**Consultation Response from KC,
Ecology Unit**

2024/90072 land at, Bradley Villa Farm, Bradley Road, Bradley, Huddersfield, HD2 2JX

Discharge of conditions 13 (cycle parking), 14 (electric vehicle charging), 16 (waste management), 33 (air source heat pumps) and 36 (external lighting) of previous permission 2021/92086 for erection of 277 residential dwellings and associated infrastructure and access

PROJECT: BRADFORD ROAD HUDDERSFIELD  
 TITLE: Proposed Lighting Design Layout

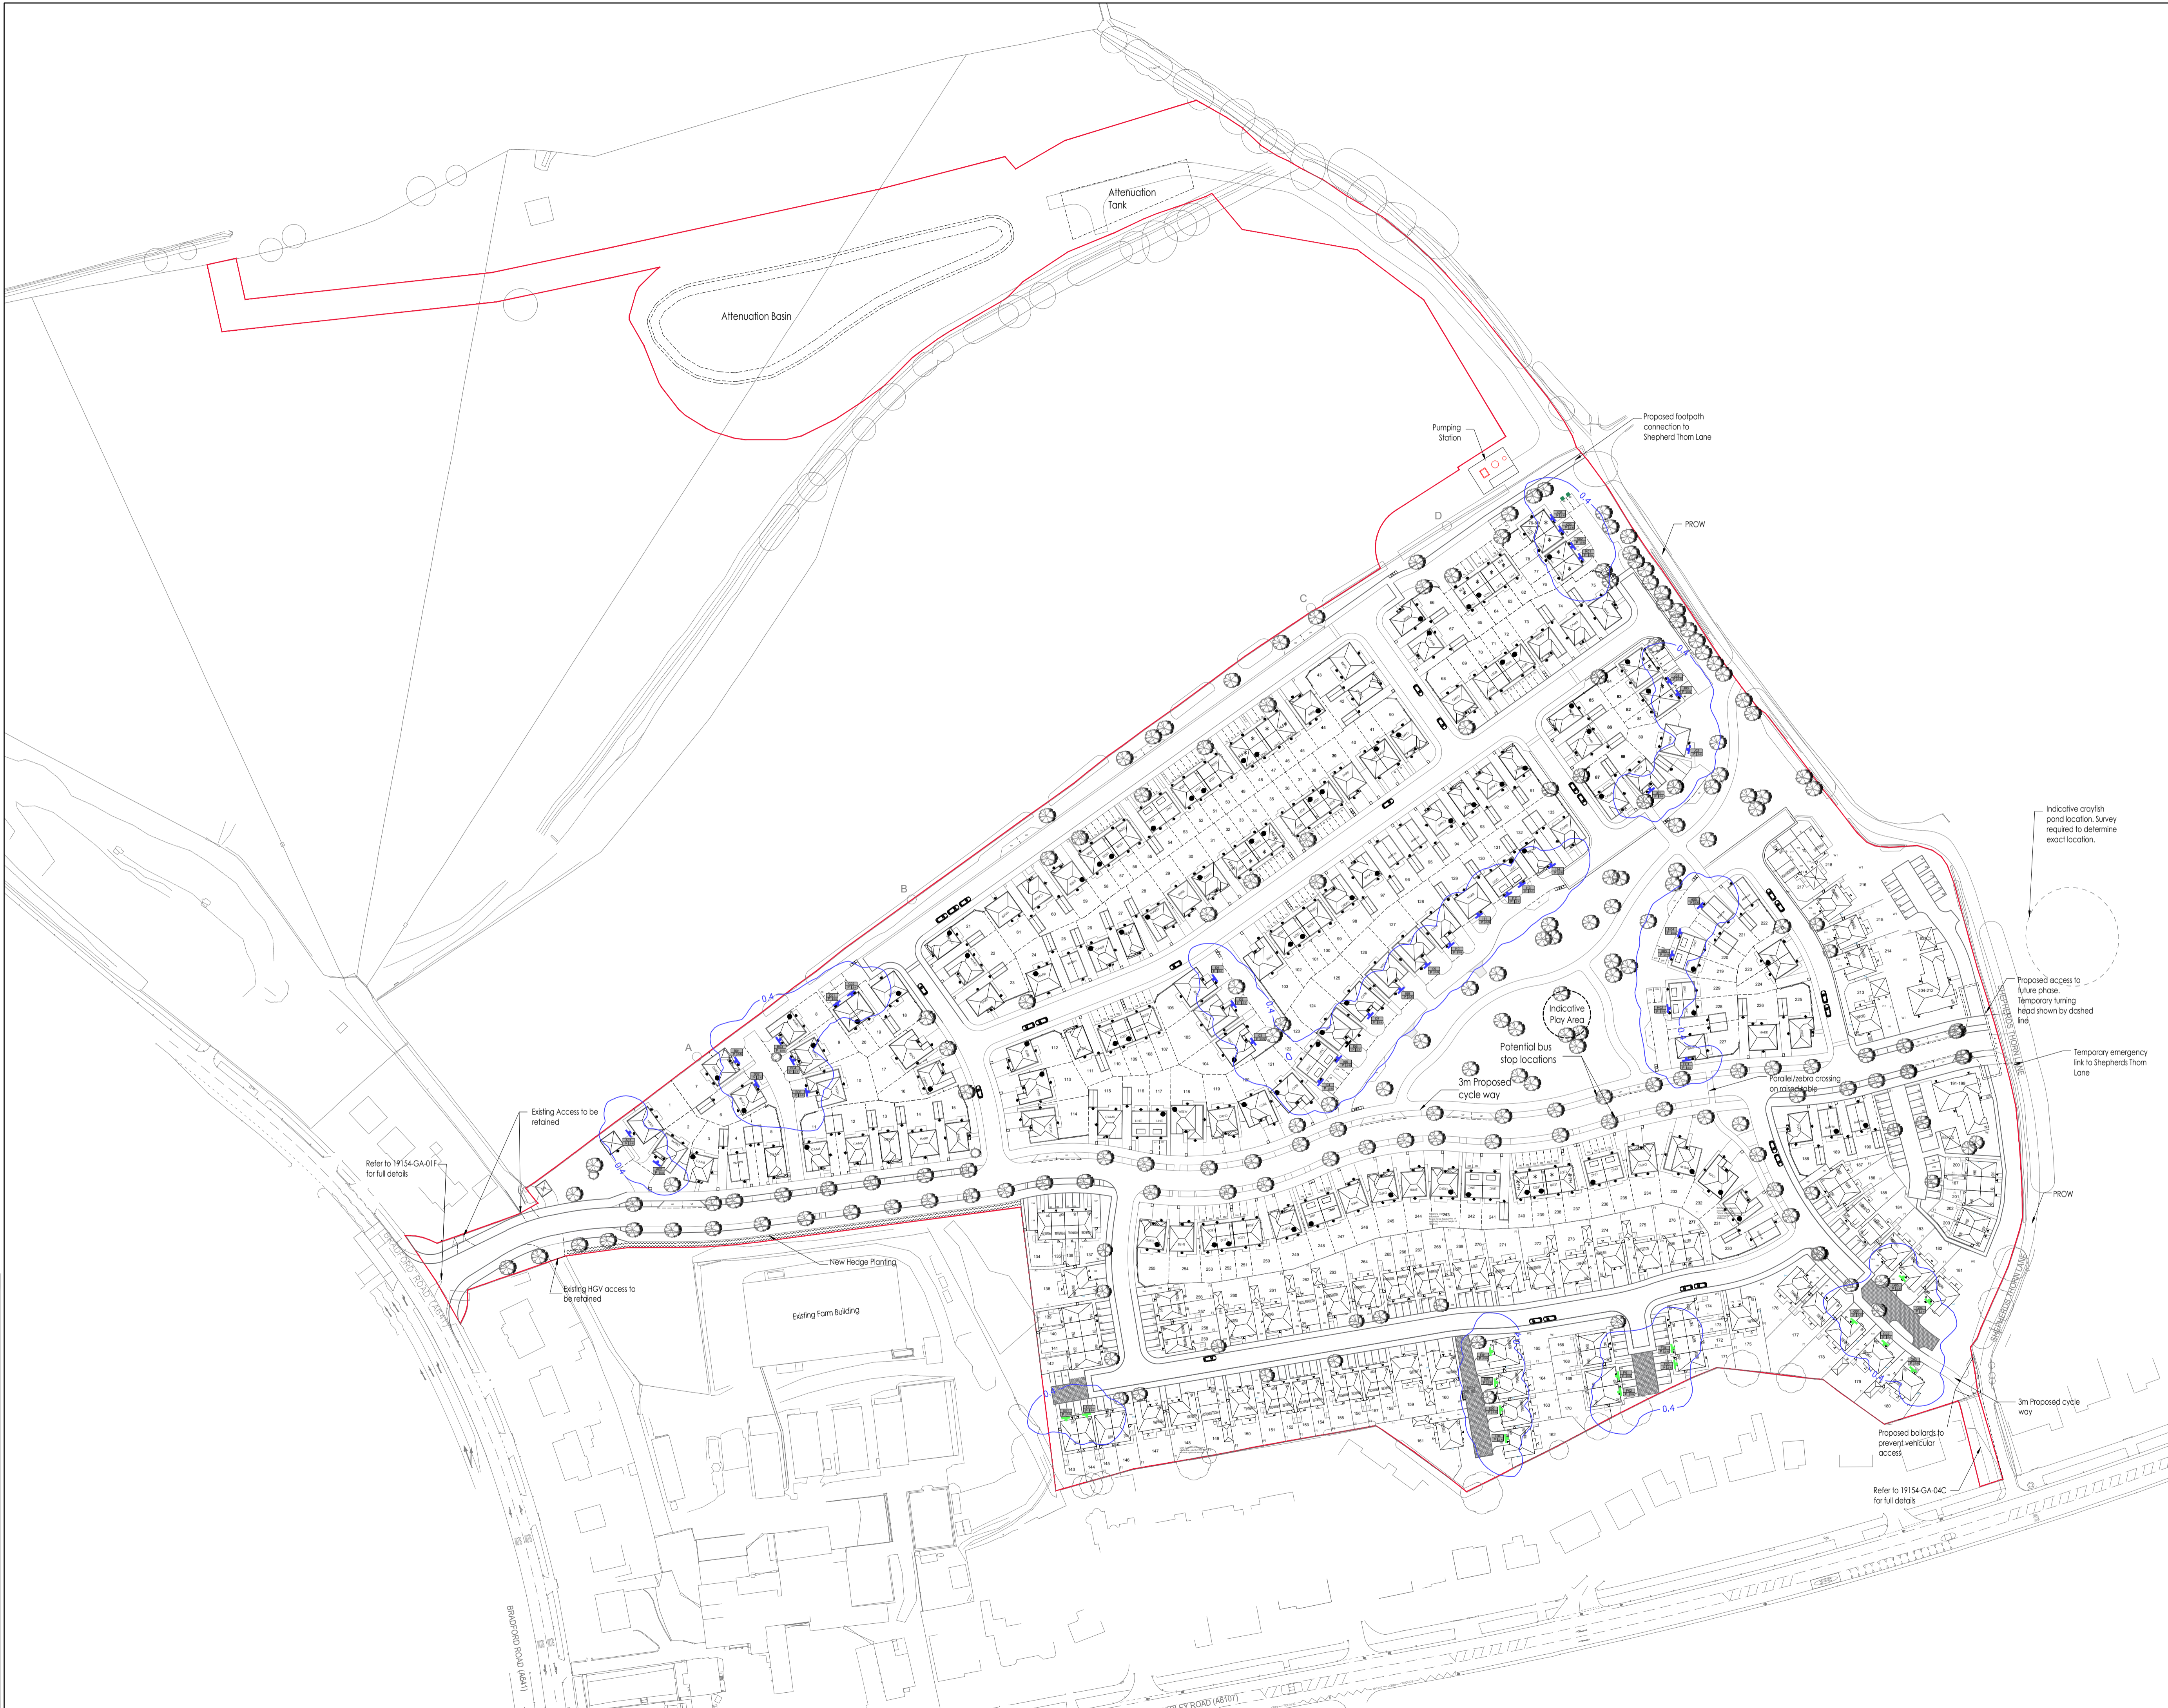
The submission does not fully meet the requirements placed on condition 36 on previous permission 2021/92086 and as such, I cannot support the discharge of any conditions pertinent to biodiversity. Once sufficient and relevant information has been submitted KC Ecology should be re-consulted.
